Recommendation Report for Planning Permission for Works or Extension to a Dwelling

REF NO: P/108/21/HH

LOCATION: 10 Dukes Meadow
Pagham
PO21 3PJ

PROPOSAL: Removal of existing conservatory and erection of rear single storey extension, single storey side extension, single storey front extension & loft conversion to form new first floor with front and rear dormer projections (resubmission following P/76/21/HH).

sheet 2 a of 3

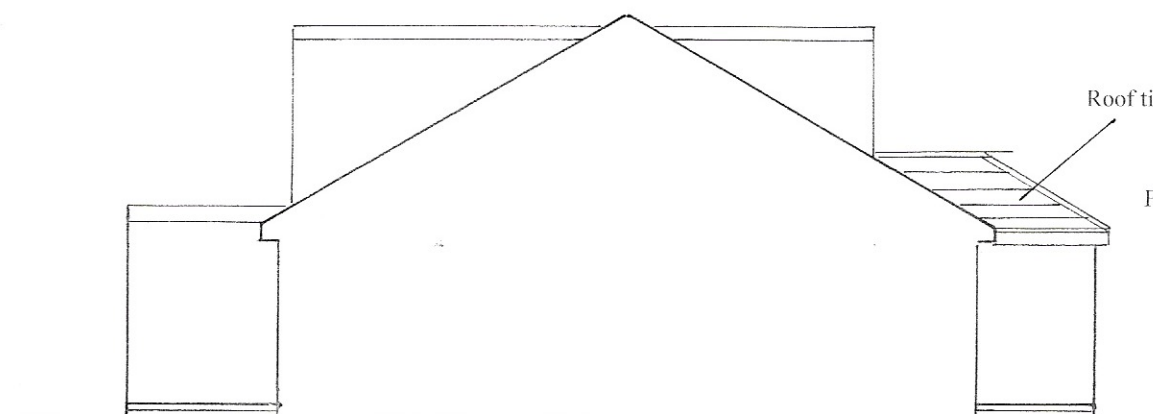
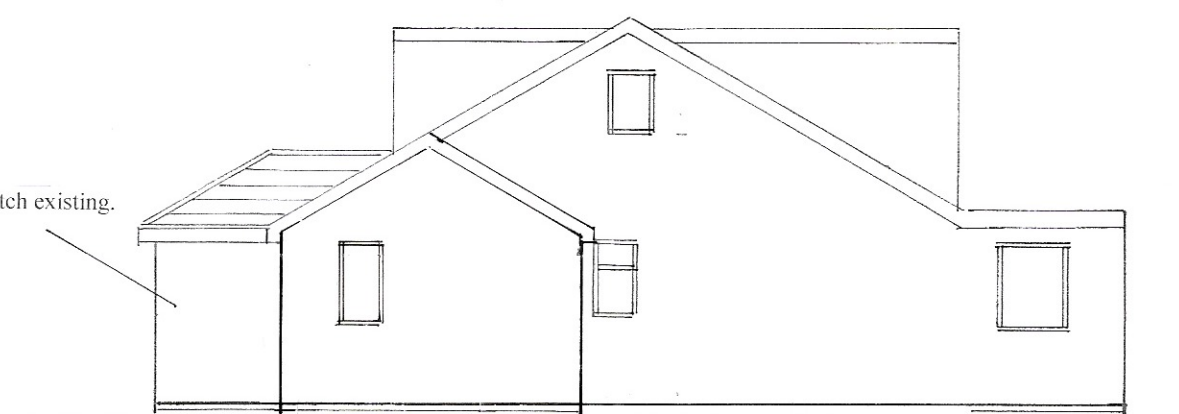
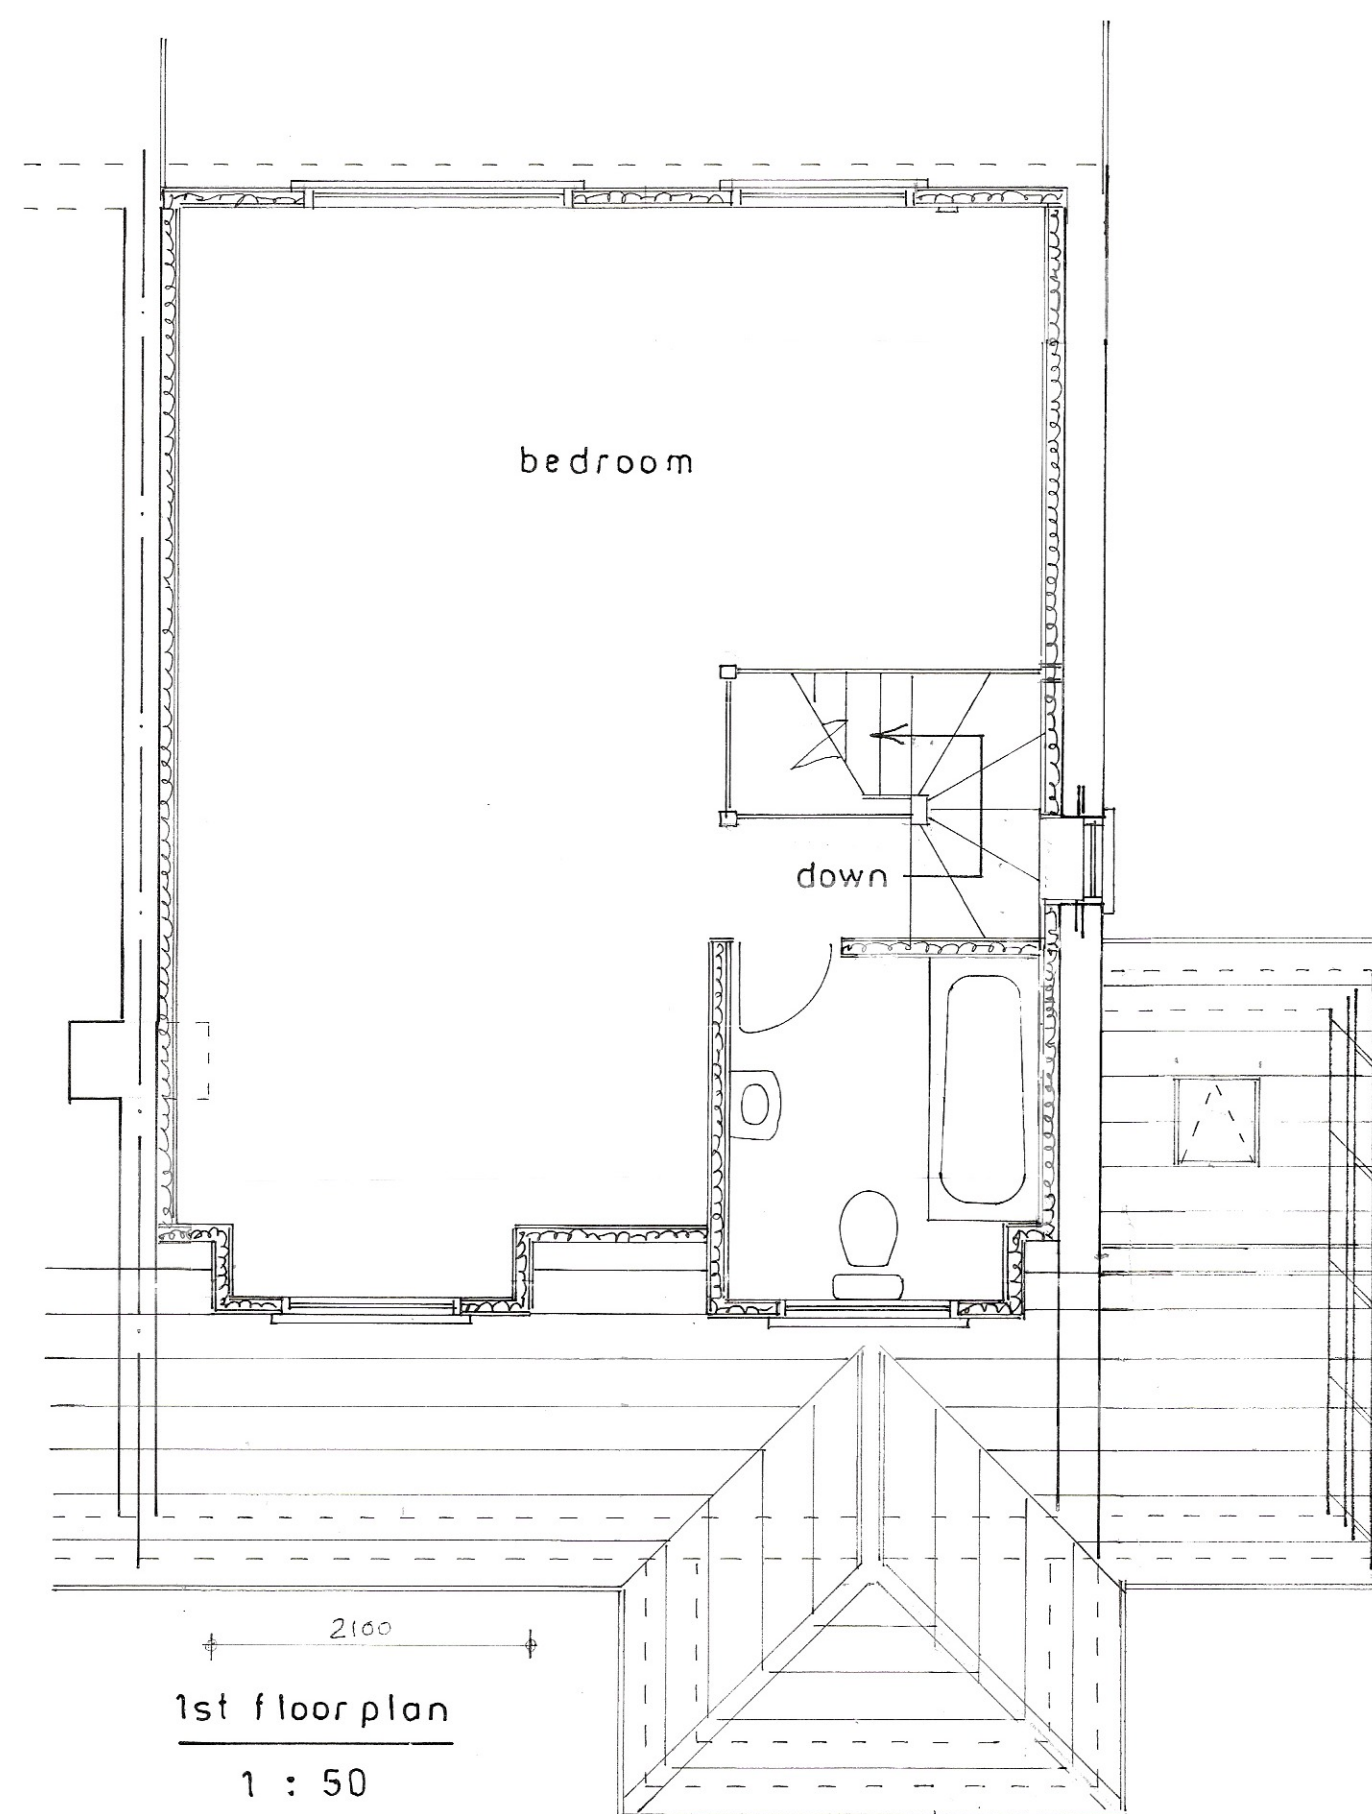
The two dormers to front (west) will each have a width of 2.11m and a depth of approx. 2.81m. The height to top of flat roof will be approximately 1.63m. The rear dormer will have a width of approximately 6.01m and a depth of approximately 4.08m. The height to top of flat roof will be approximately 2.40m.

Due to the siting of dormers to front (west) they will be highly visible from street scene however due to smaller design of two individual dormers they are less dominant so do not adversely impact street scene or character of surrounding area. Whilst the dormers are not common in the vicinity of Dukes Meadow, there are properties within locality along Mayfield Close to east of site which have dormers so is considered acceptable.

Due to siting of dormer to rear (east) the large box shaped design adds bulk to rear of the property, however it could be done under permitted development dependent on the size and materials to be used.

The proposed materials seem to match existing dwelling and consist of brickwork walls, Marley Cedral Cement Boarding to dormers - dark grey - C15, tiles and felt flat roof, UPVC windows and doors so complies with policy D DM1 and D DM4 of the Arun Local Plan.

The Dormer to rear (east) will have two new windows to rear (east) at first floor. The extensions to rear will have new French doors (3 door panes) and two new windows to rear (facing east) at ground floor level. Due to position of these windows and doors there is increased risk of overlooking to neighbouring property to rear (east) however gap of around 9.10m remaining to rear boundary does not cause harm to overlooking to rear or side due to siting of extension beyond building line to south.

sheet 1 a of 3

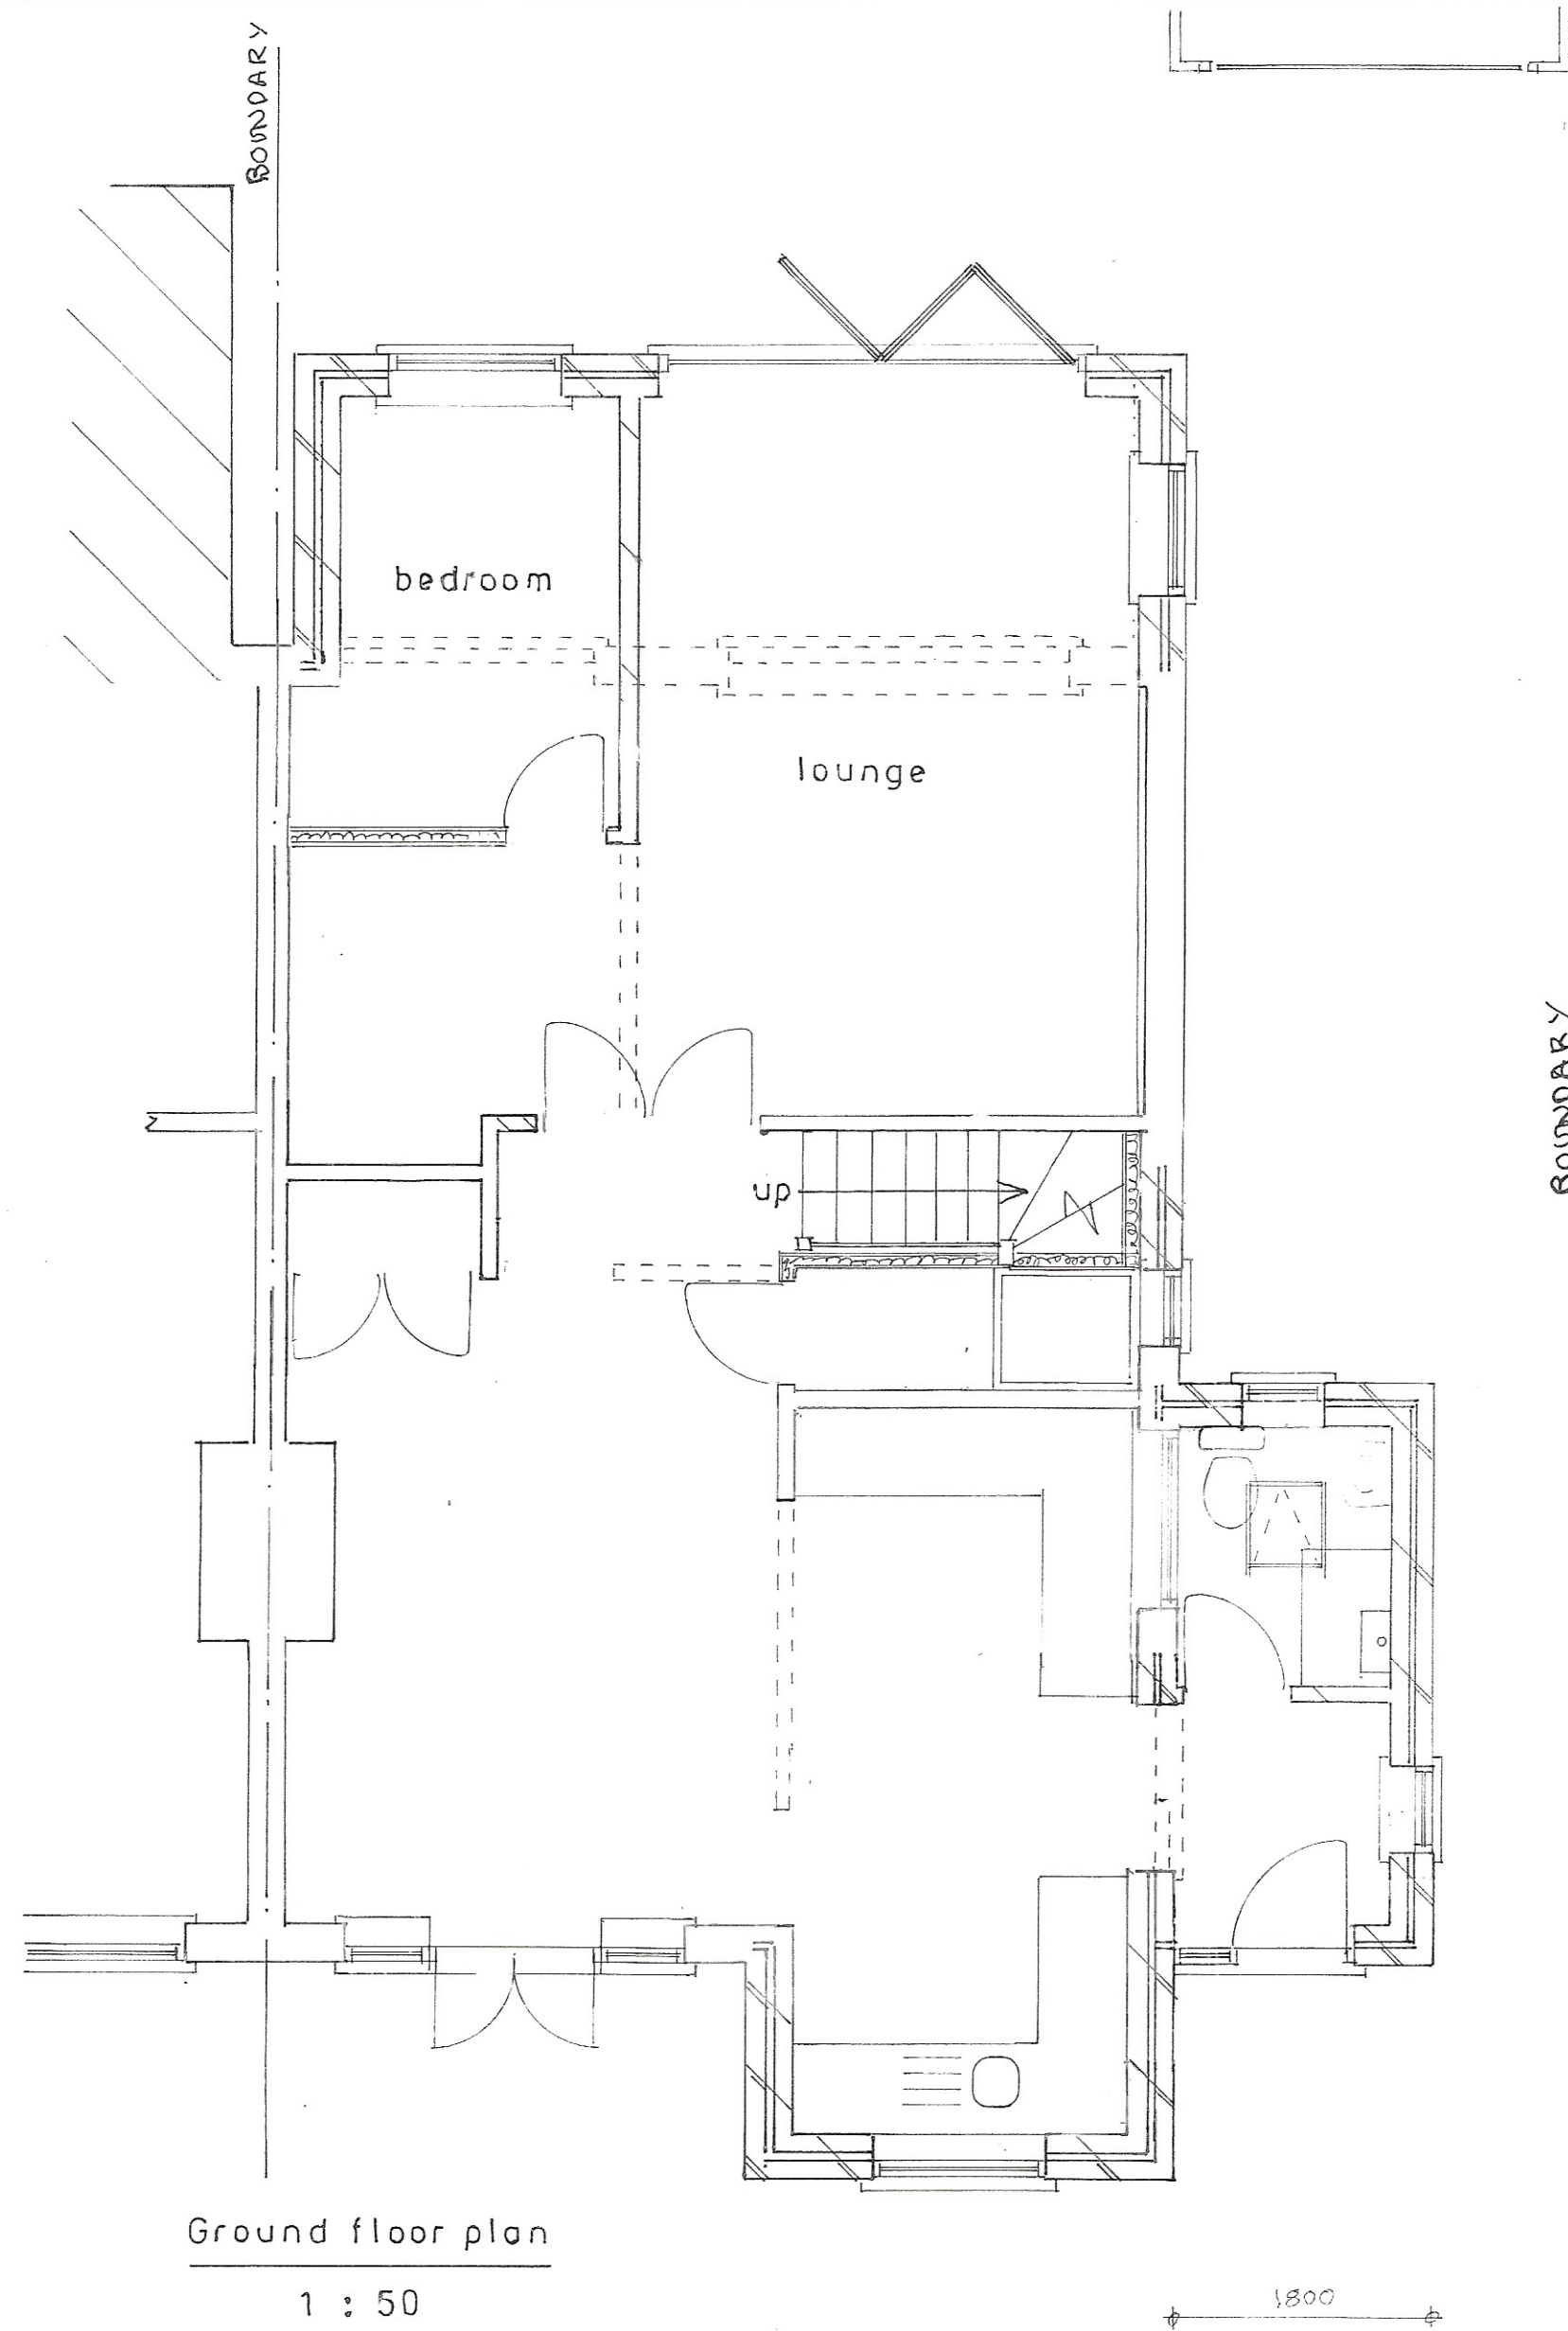
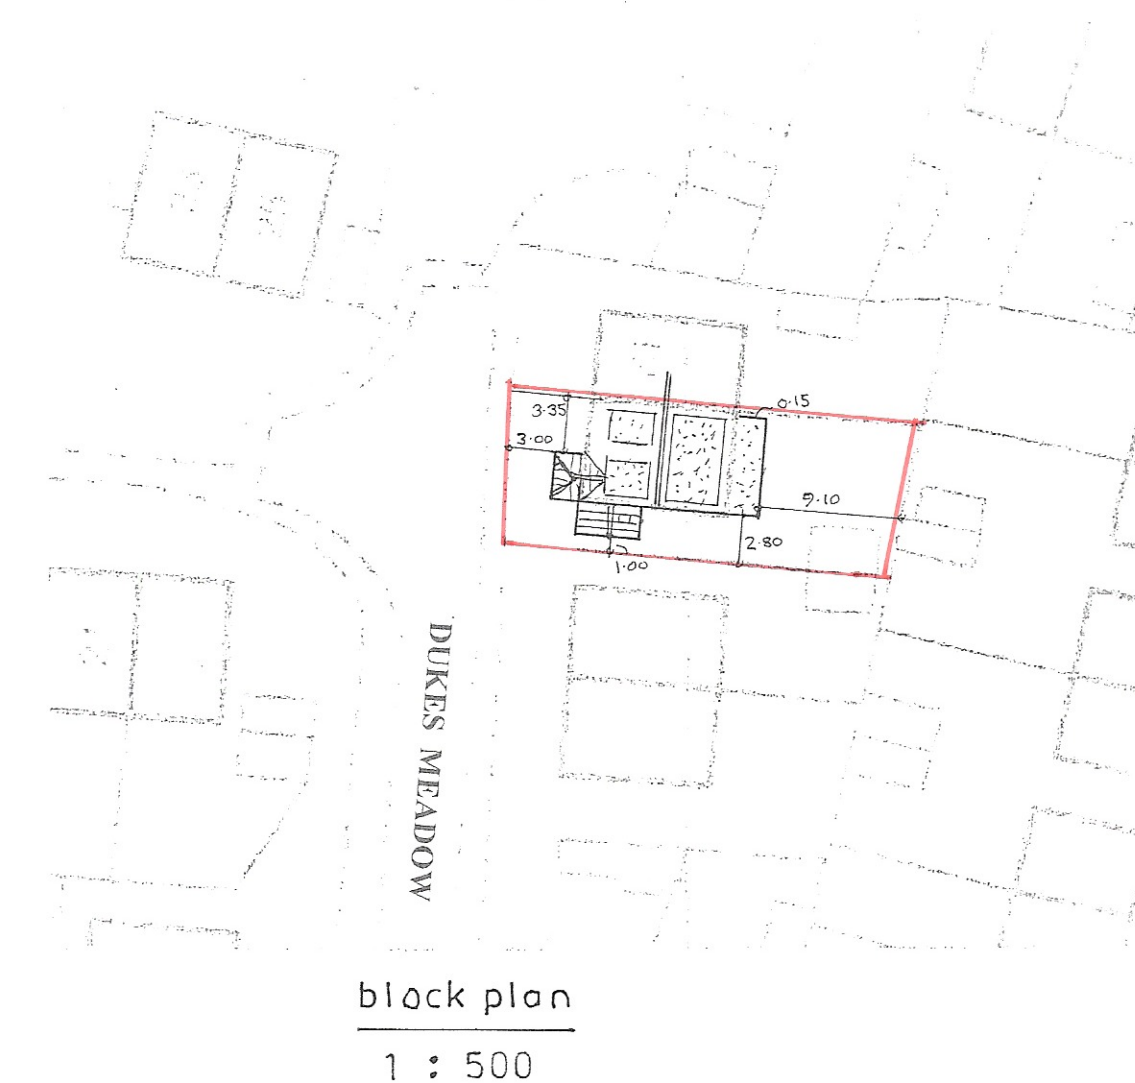
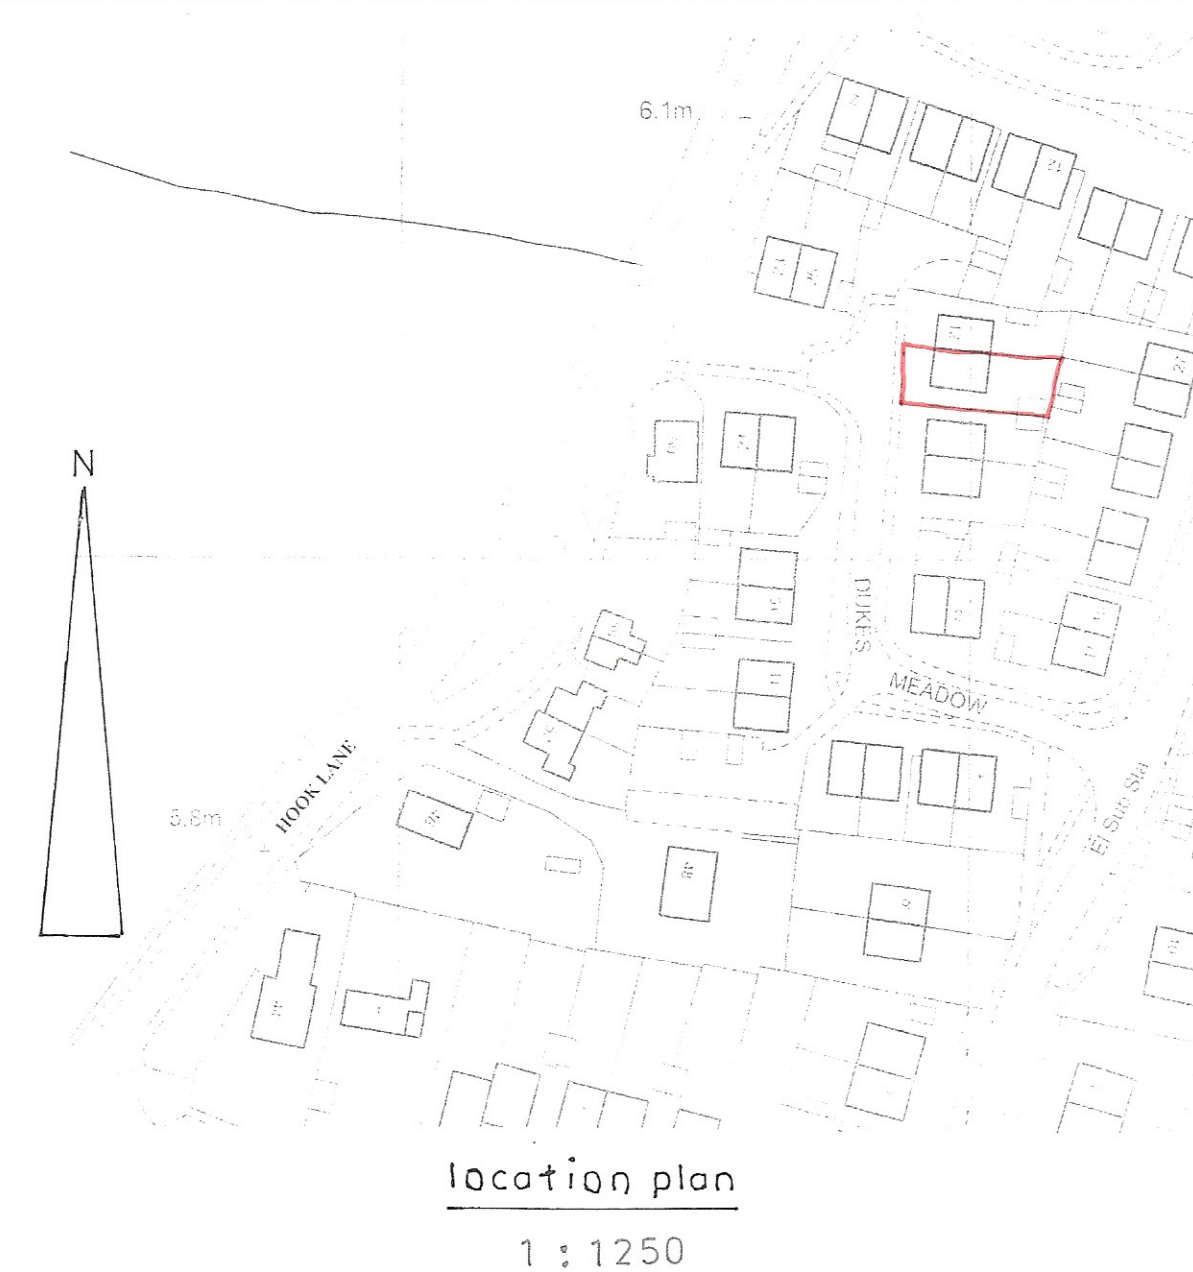
The property has a 5.85m by 1.97m conservatory to the rear that will be removed. The extension to rear (east) will have a width of 6.22m and depth of approx. 2.03m. The height to flat roof will be approximately 2.86m. Due to siting to rear it is less visible from street scene so does not adversely impact street scene or character of area so complies.

The extension to front (west) will have a width of approximately 3.02m and depth of approximately 1.51m. The height to pitched roof will be approximately 3.55m.

The extension to side (south) will have a width of approximately 4.16m and a depth of approximately 1.78m. The height to pitched roof will be approximately 3.84m.

Due to siting of extension to rear (east) beyond building line to north, it will impact the 45 degrees test when looking from rear ground floor windows of neighbouring property number 12. However being at single storey and existing boundary fence reduces impact so is acceptable. There is around 2.80m remaining to side (southern) boundary and 9.10m to rear (east) boundary so is acceptable.

Due to siting of extension to side (south) there is increased risk of overshadowing or overbearing effects to number 8 Dukes Meadow to south however being at single storey, existing boundary fence and gap of around 1m to southern boundary and 3.38m to neighbouring property there is no adverse harm.
